**From:** Slaidburn and Easington Parish Council c.o Alison Robinson  
<saepcAR@outlook.com>  
**Sent:** 15 June 2020 19:16  
**To:** Planning  
**Subject:** Planning Application - 3.2020.0328 / 3.2020.0355  
**Categories:** Yellow Category

I write regarding the above planning applications.

PROPOSED  
 BACKHOUSE FARM  
 DALE HEAD  
 SAIDBURN  
 scale 1:100 November 2019

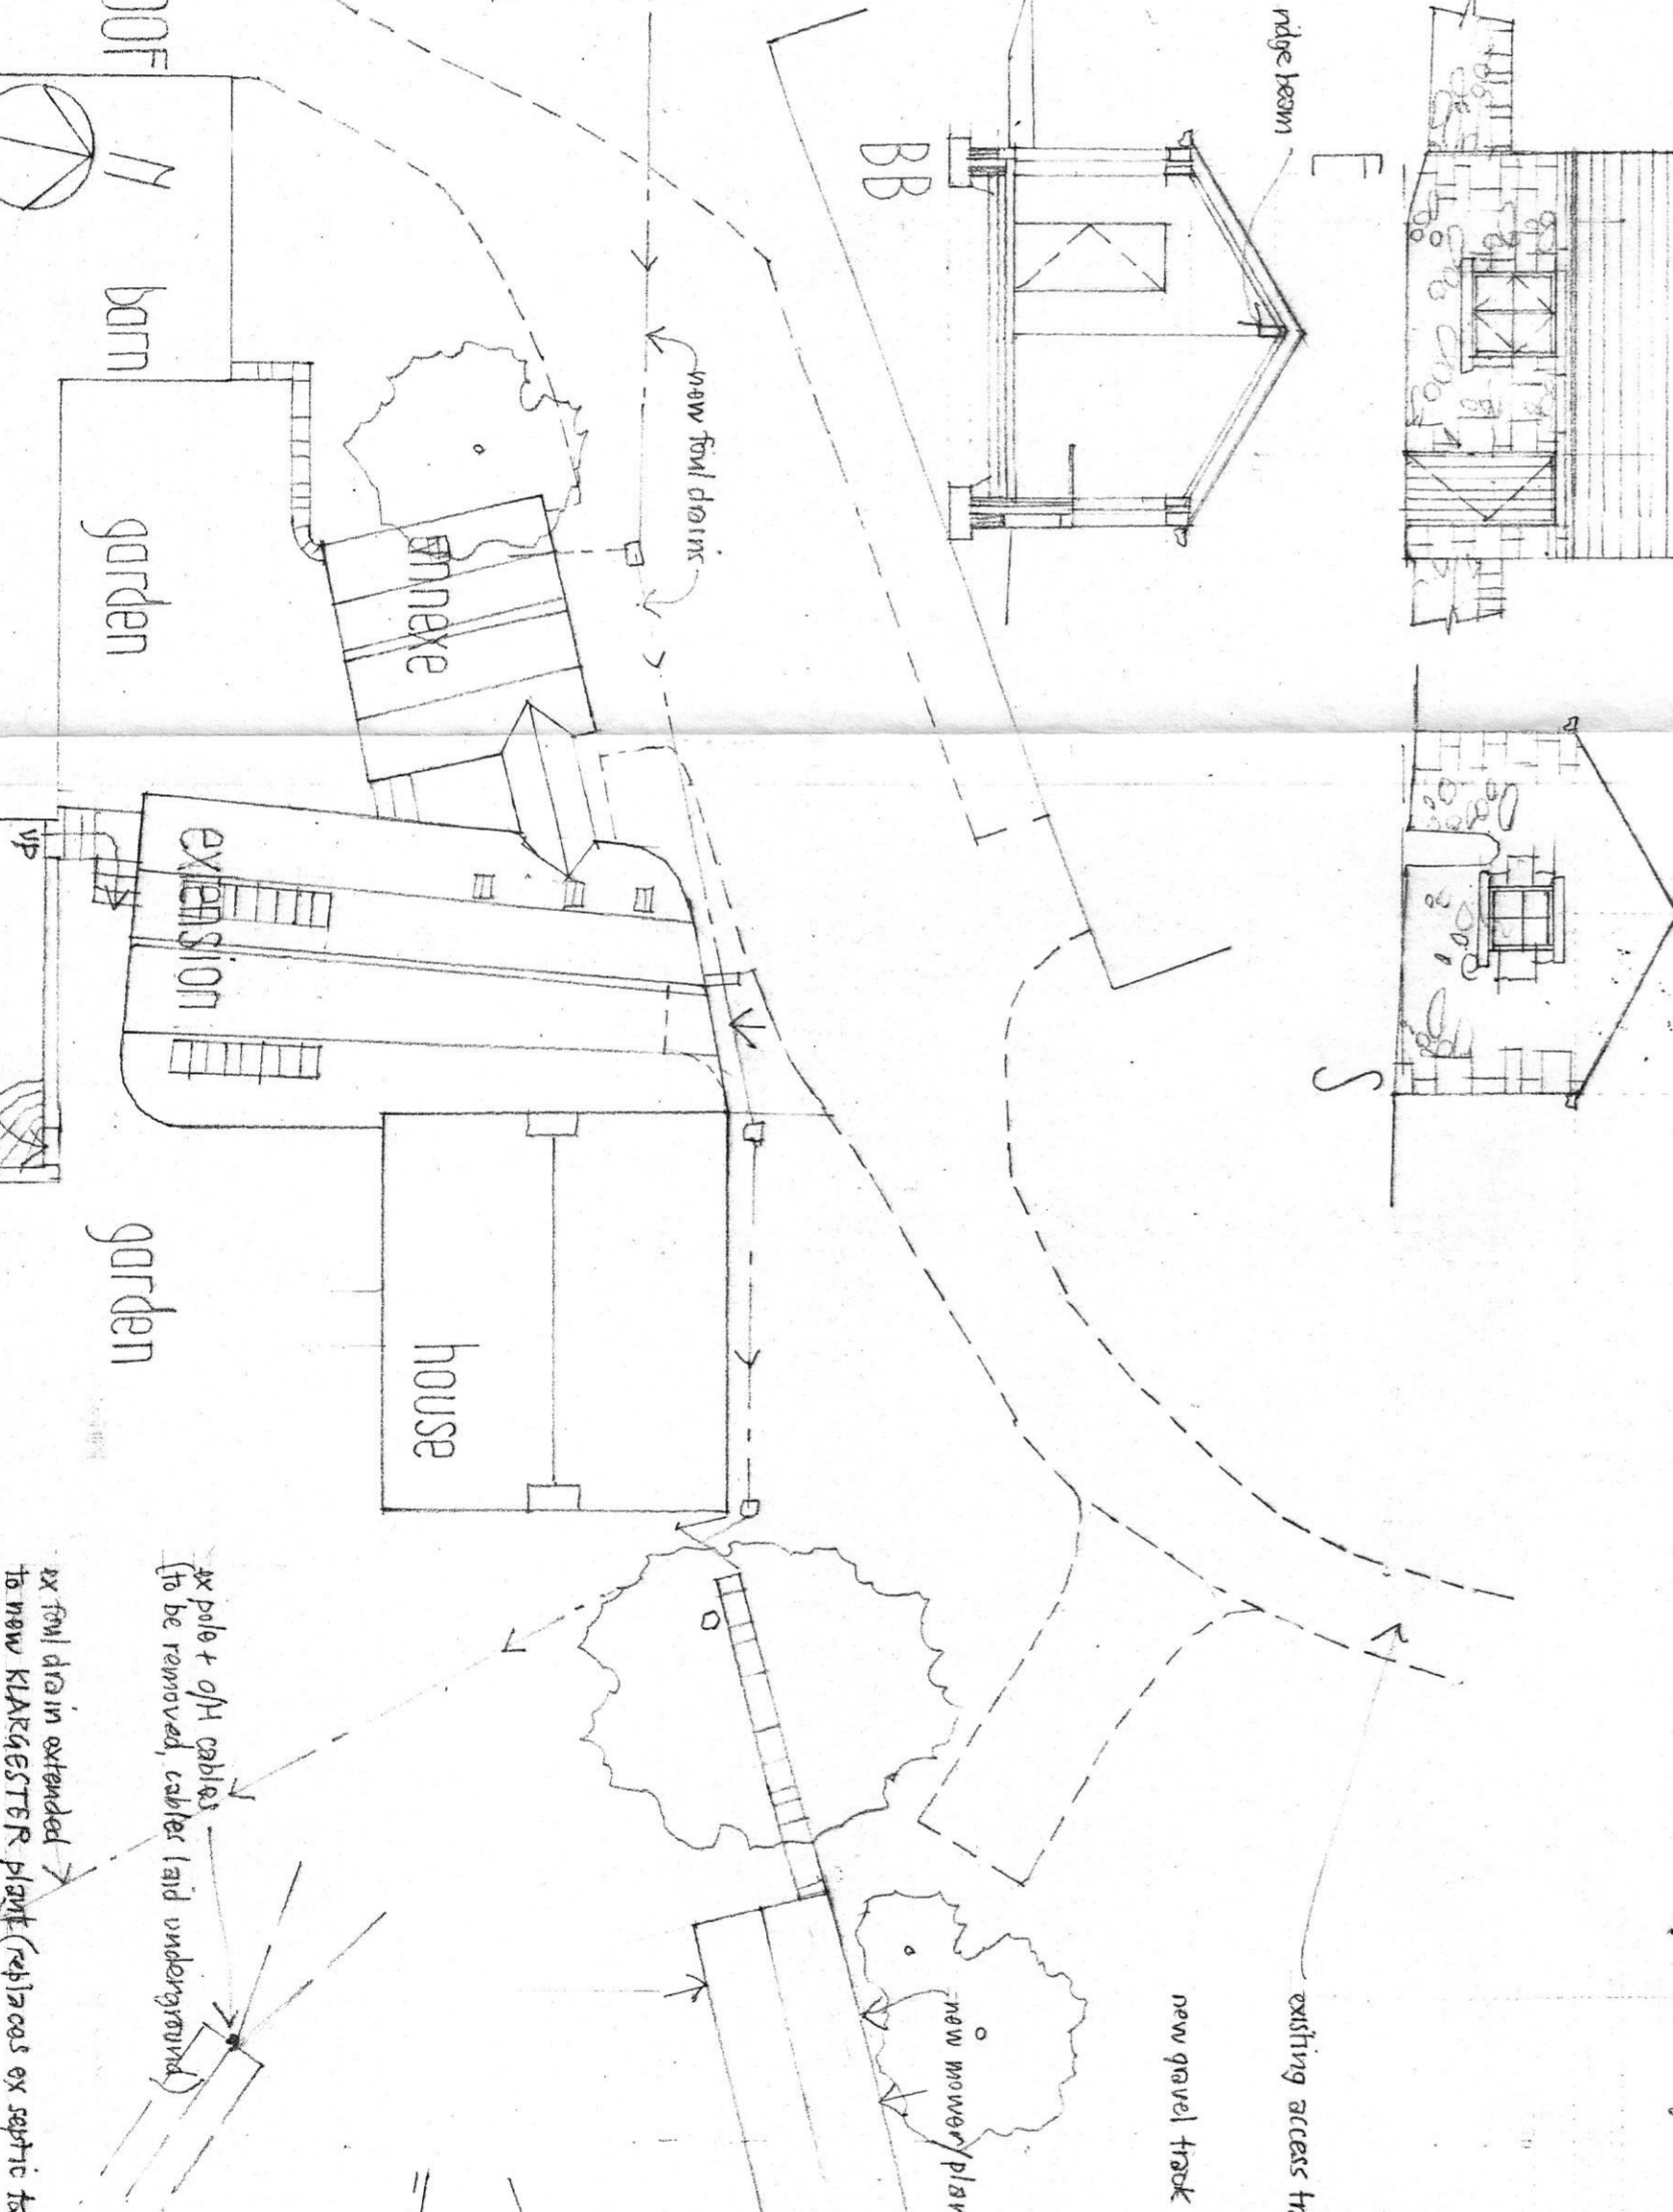
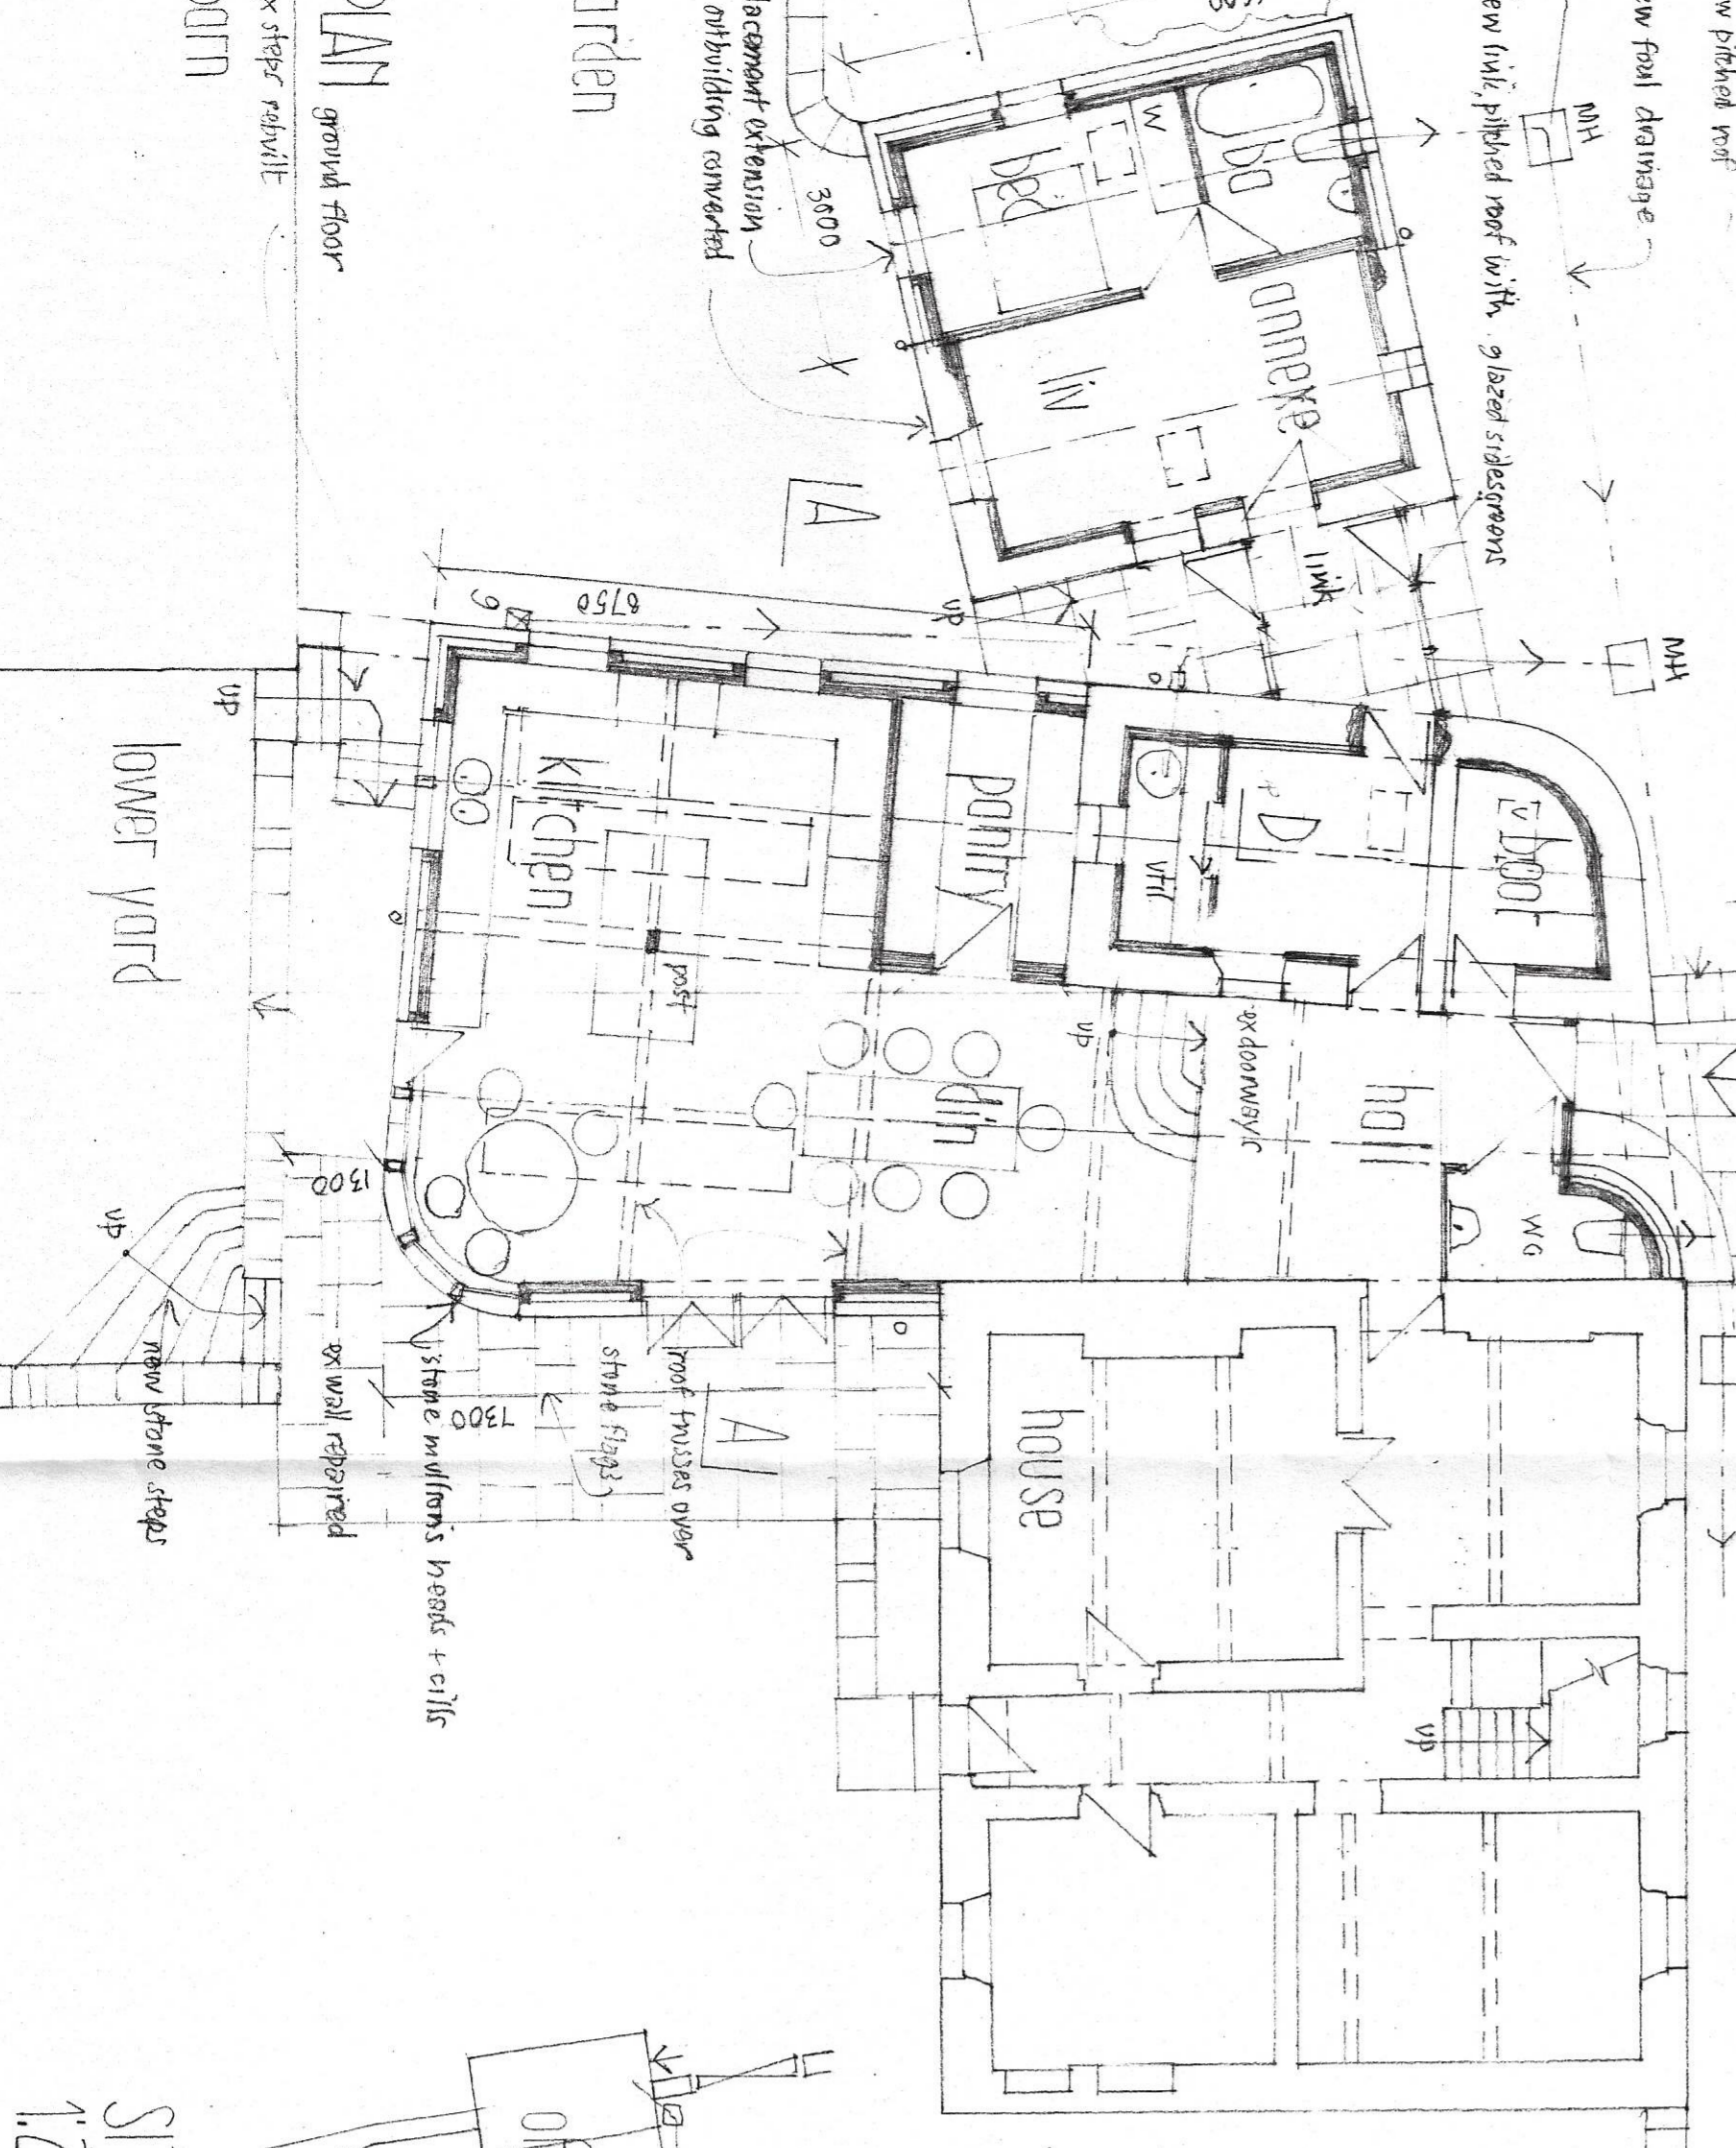
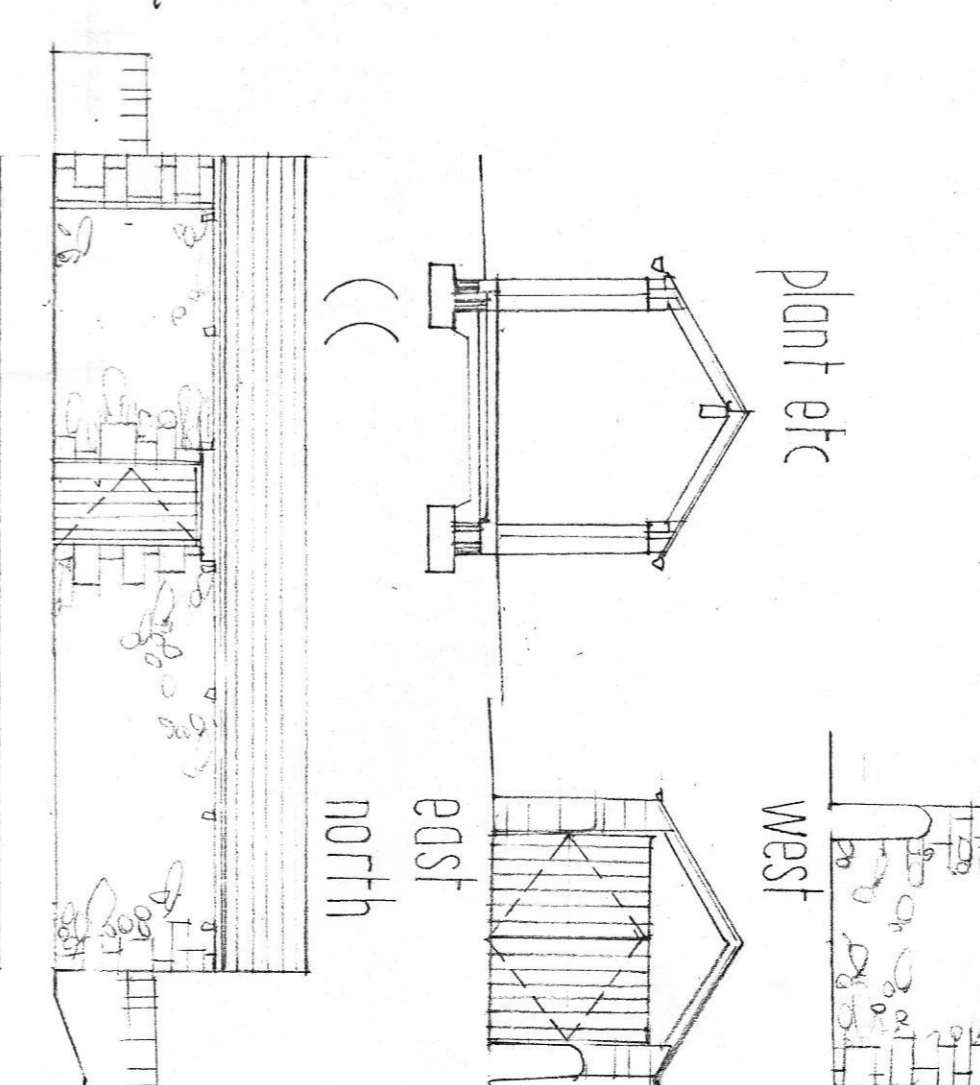
The only comment that the Parish Council wish to make is in relation to the blue slate on the extension. They would recommend that to keep the extension in keeping with the current building stone flag slates are used.
